**Consultation Response from KC,
Highways Development Management**

2025/93066 land off, Lockwood Road and Albert Street, Lockwood, Huddersfield, HD1 3QW

Change of use of disused land to form car valeting facility (sui generis use) with welfare and storage unit.

Date Responded: 15/04/2026

Project No. 2025 Enquiry 70	Project Title proposed site and floor plan	Scale 1:200 @A3 size	Date 31/10/2025
Drawn By	Reviewed By MC		
Drawn No. 101	Reviewed Title		Revision A

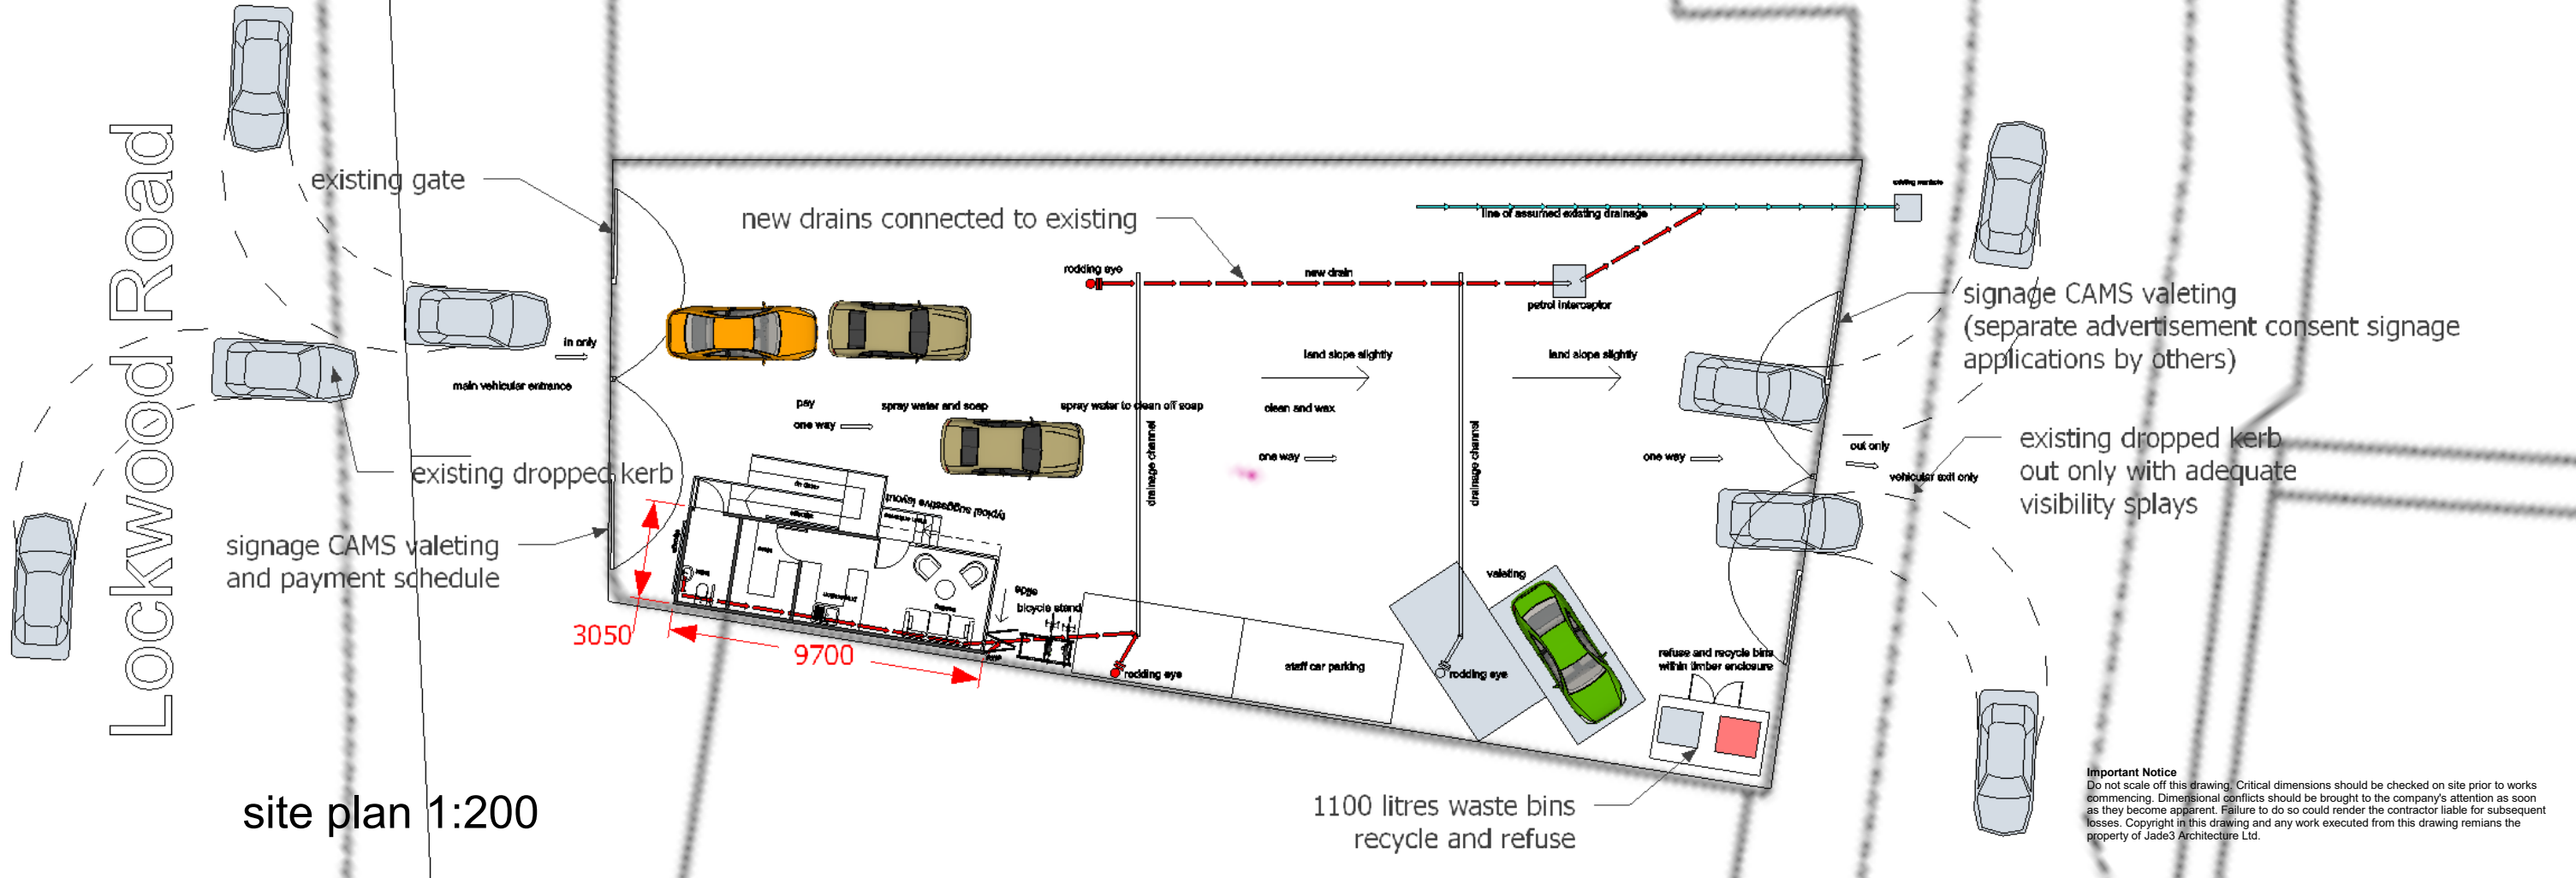
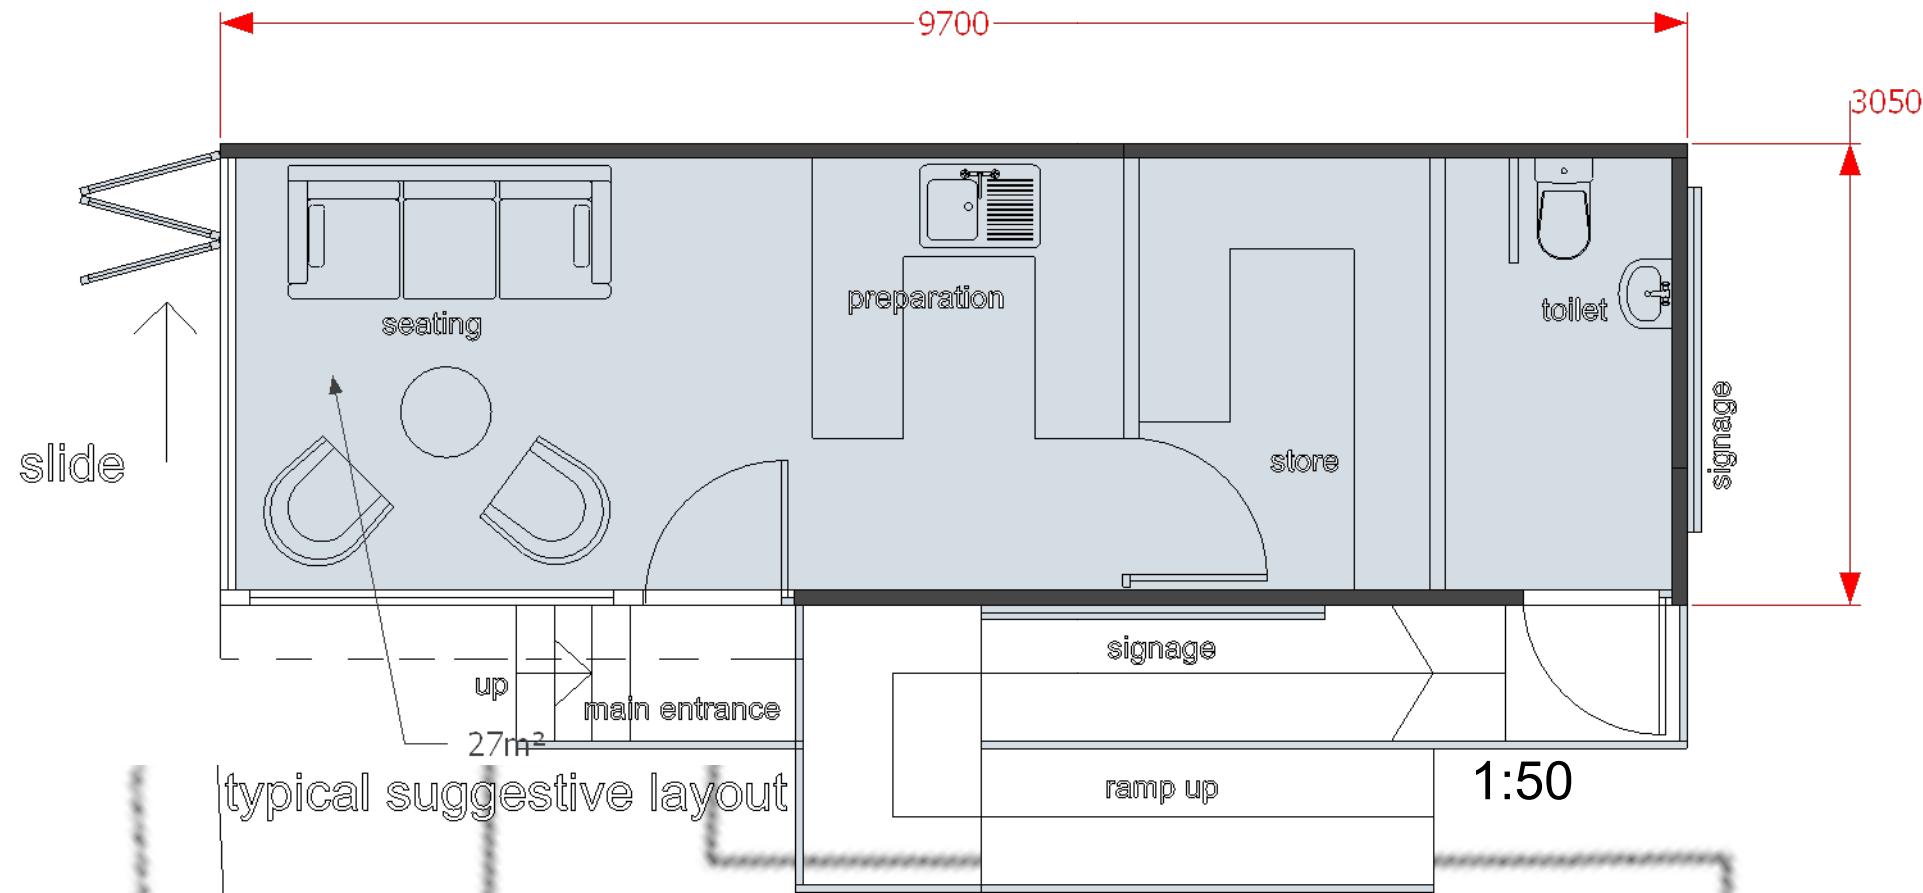
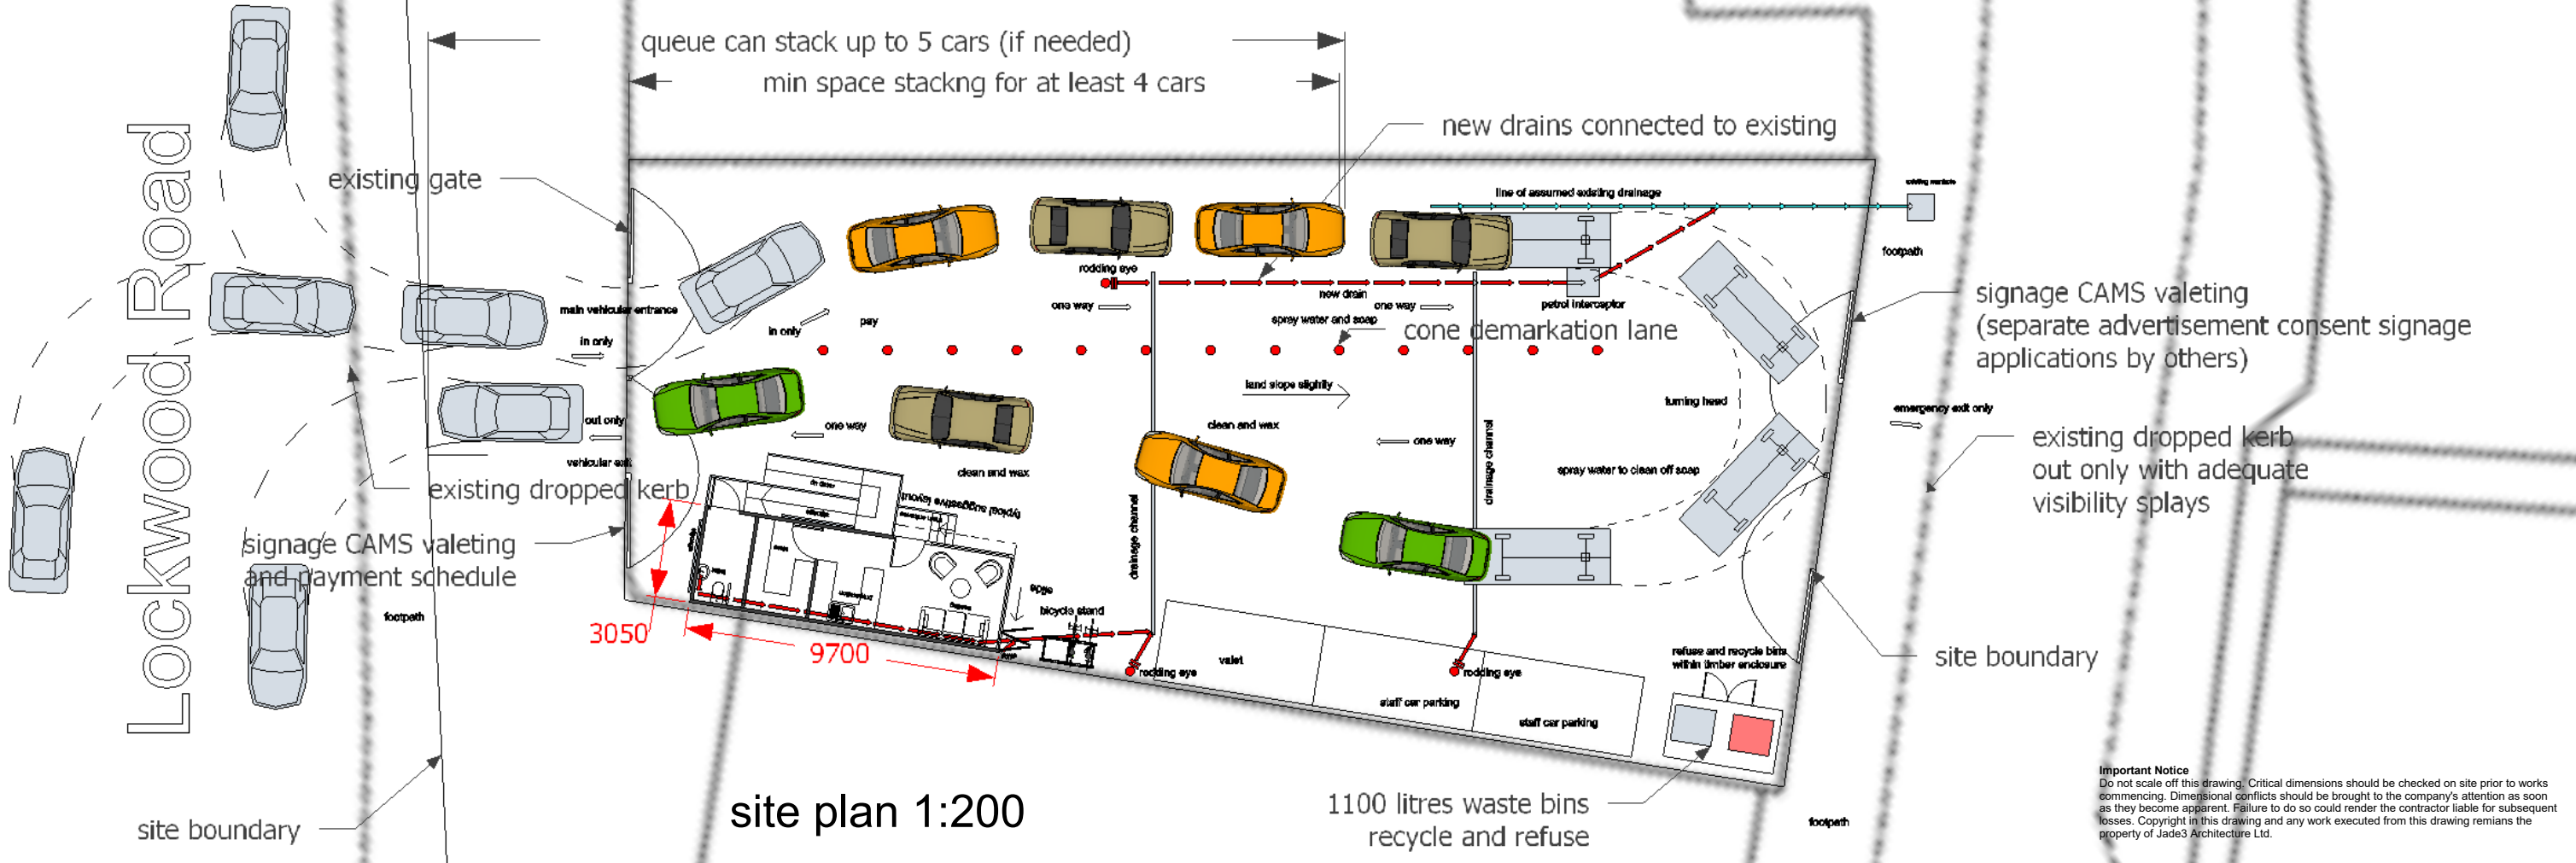
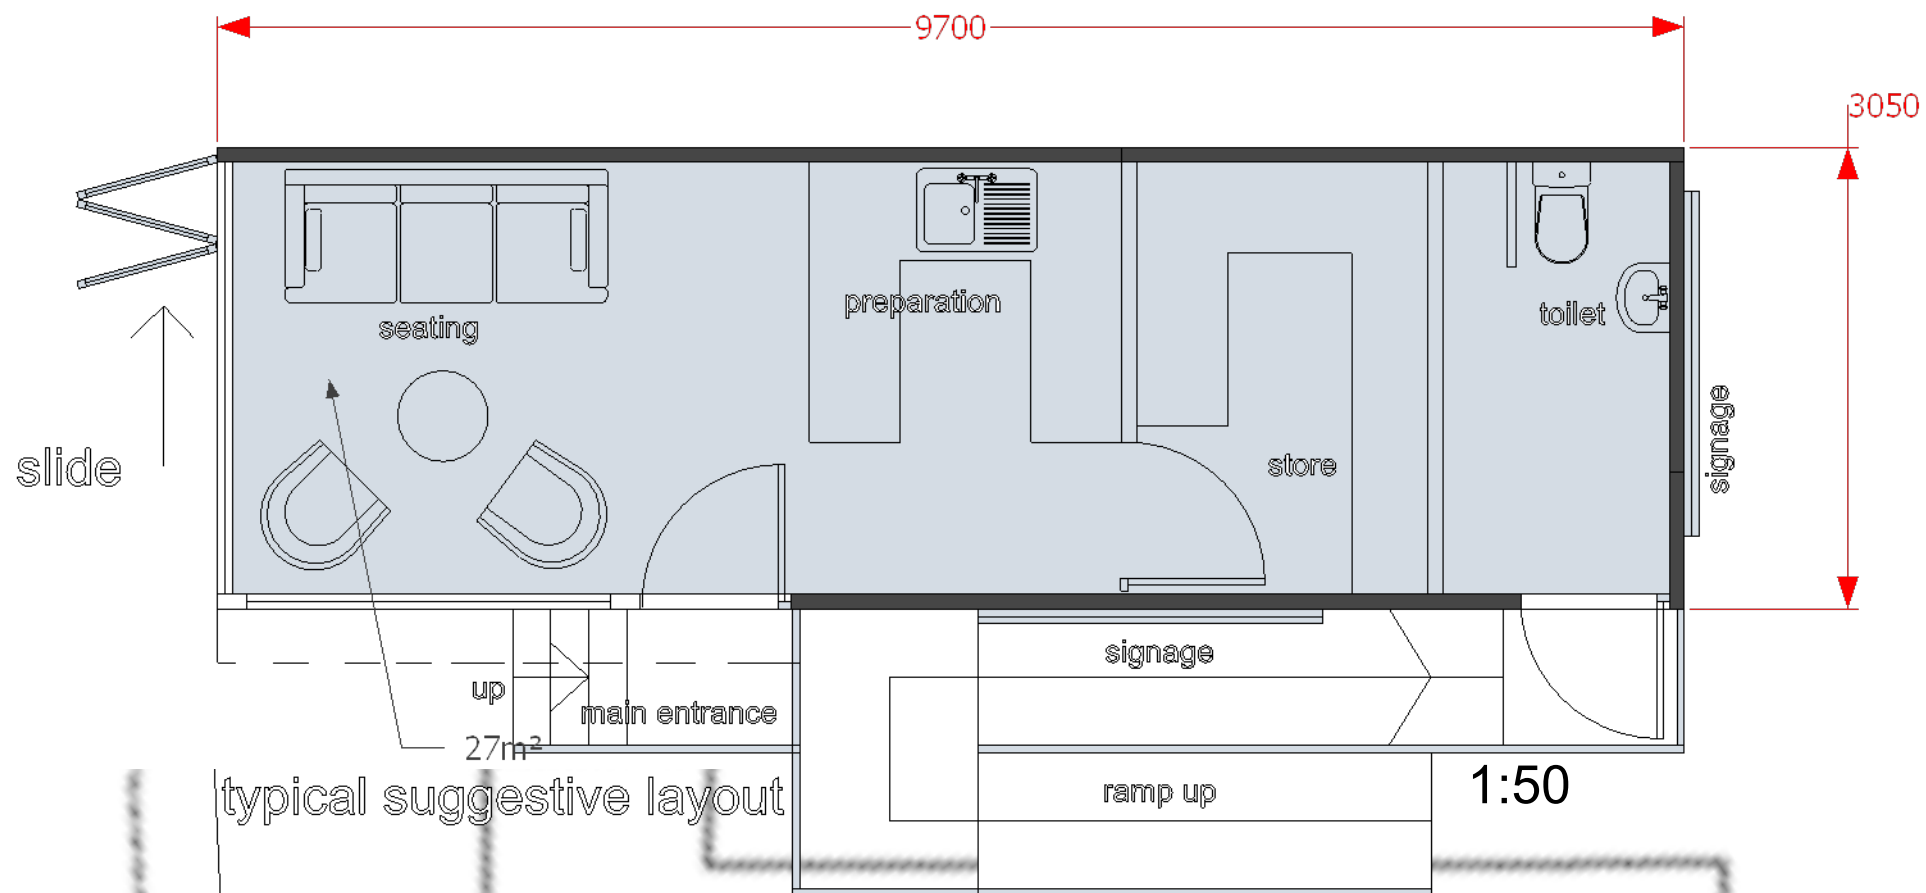
With reference to the submitted plan, the site does not appear to be of sufficient size to accommodate an adequate queueing and/or waiting area within the site.

The plan shows the location of the wash bays being close to the entrance of Lockwood Road leaving very little space for vehicles entering the site to wait and I am concerned that waiting vehicles will queue out onto Lockwood Road blocking both the bus lane and running lanes.

A616 Lockwood Road is a busy main road connecting Huddersfield with the south of the district and any queueing at this location would be detrimental to Highway safety at this location.

A revised plan showing the location of the wash bays, circulating traffic and a larger waiting area needs to be provided to demonstrate that there is adequate space within the site to accommodate this proposal.

The proposal uses the existing accesses to the site, and it may be better to reduce this to one access to enable more capacity within the site.

The Applicant states that sightlines at the site access are adequate. However, these have not been demonstrated. A revised plan showing that the required sightlines can be achieved should be submitted

For a 30mph speed limit sight lines of 2.4m x 43m should be achievable and demonstrated on a suitable plan, any shortfall of this requirement should be in accordance with 85%ile wet weather speed readings (if below 30 mph).
